REFUSAL OF CONSENT TO DISPLAY ADVERTISEMENT(S)

Application Number: 2026/64/90572/W

ADVERTISEMENT CONSENT FOR INSTALLATION OF 1 BT STREET HUB, INCORPORATING 2 DIGITAL 75INCH LCD ADVERT SCREENS, AND ASSOCIATED BT PHONE KIOSK REMOVAL (WITHIN A CONSERVATION AREA)

At: PAVEMENT O/S, UTILITA, RAMSDEN STREET, HUDDERSFIELD, HD1 2BQ

EXISTING AND PROPOSED ELEVATIONS

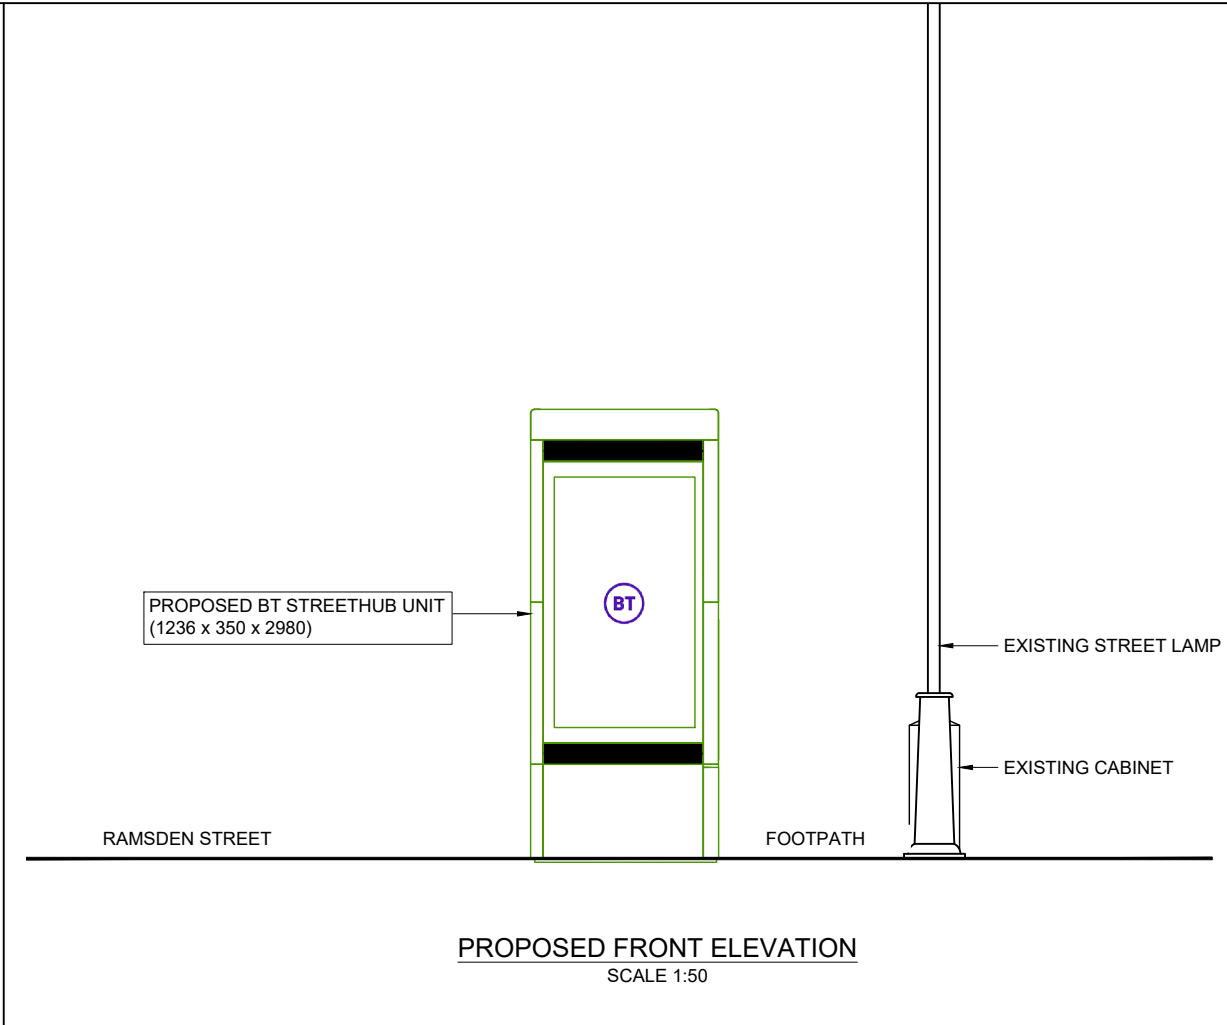
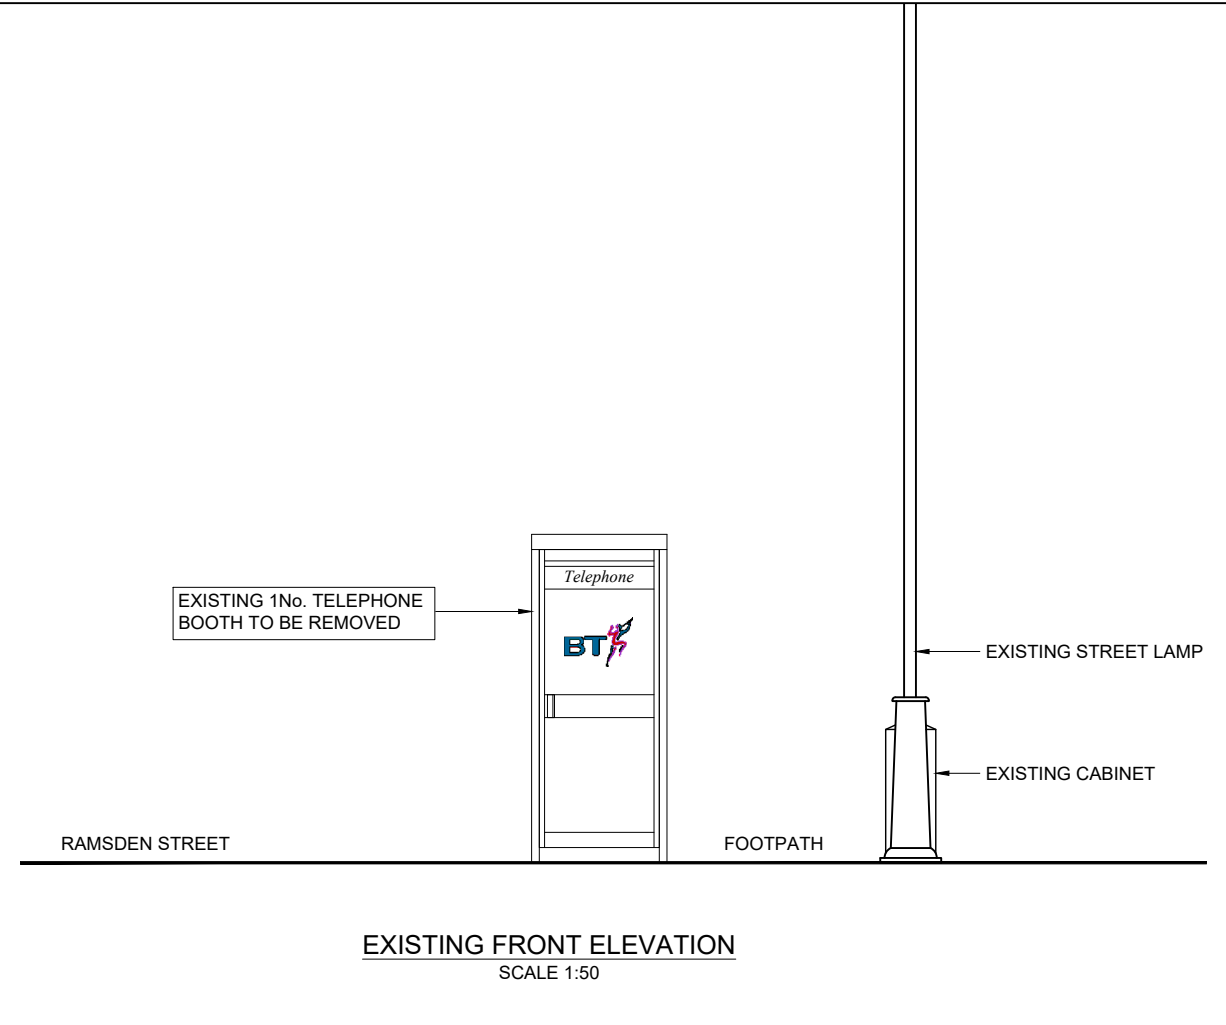
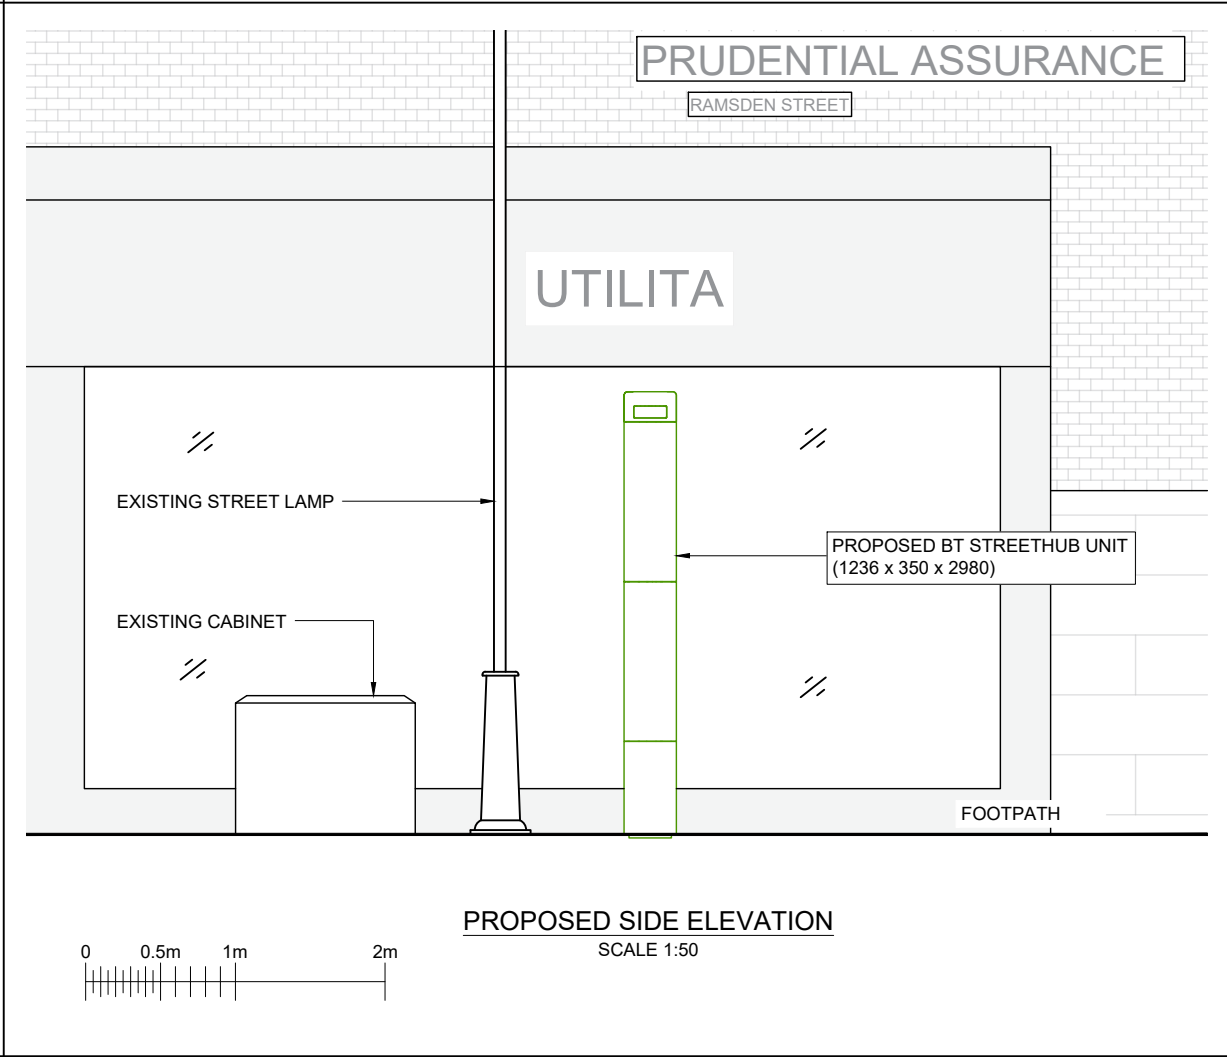
1. The proposed digital display screens, owing to their scale, prominent siting, means of illumination and the presence of other similar installations in the immediate vicinity, would be a visually intrusive feature that causes detrimental harm to the visual amenities of the locality and less than substantial harm to the significance of the Huddersfield Town Centre Conservation Area as well as the nearby Grade II listed buildings of 71 New Street, Huddersfield Town Hall, Queensgate Market and 62 New Street and their setting.

Having regard to the cumulative impact of similar installations already in existence, including on Ramsden Street, High Street and New Street, the introduction of a further pair of digital display panels would add further illuminated street clutter which would detract from the character of the wider Town Centre, and would prejudice the aims of the Huddersfield Blueprint, a ten-year regeneration initiative to rejuvenate the town centre and enhance public spaces. Whilst the harm caused to designated heritage assets would be less than substantial, the public benefits associated with the proposed development would not outweigh the harm caused. The proposal is therefore contrary to Policies LP24(a), LP25 and LP35 of the Kirklees Local Plan, Chapters 12 and 16 of the National Planning Policy Framework, advice within the PPG regarding amenity considerations and Sections 66 and 72 of the Planning (Listed Buildings and Conservation Areas) Act 1990.

DETAILED SITE LOCATION

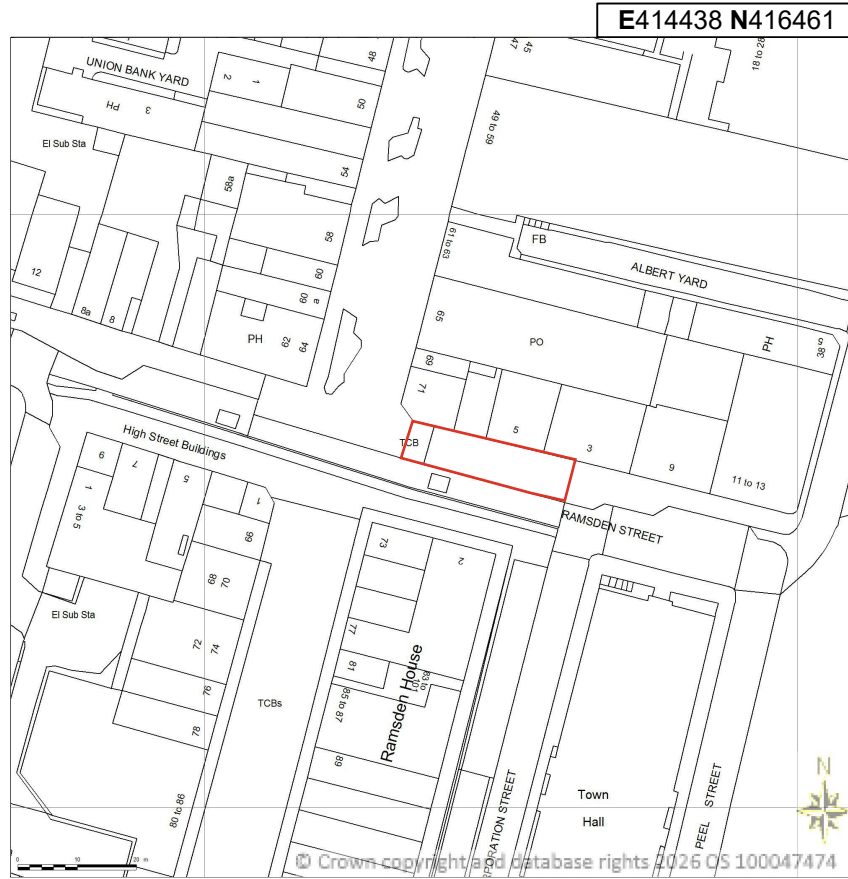
Clarification Note: Submitted plan (ref 001RevA) includes two site location plans at scale 1:1250 which show different sites. This application is assessed on the basis of the top plan (E414438N416461) as this relates to the site with the same address upon the submitted form.
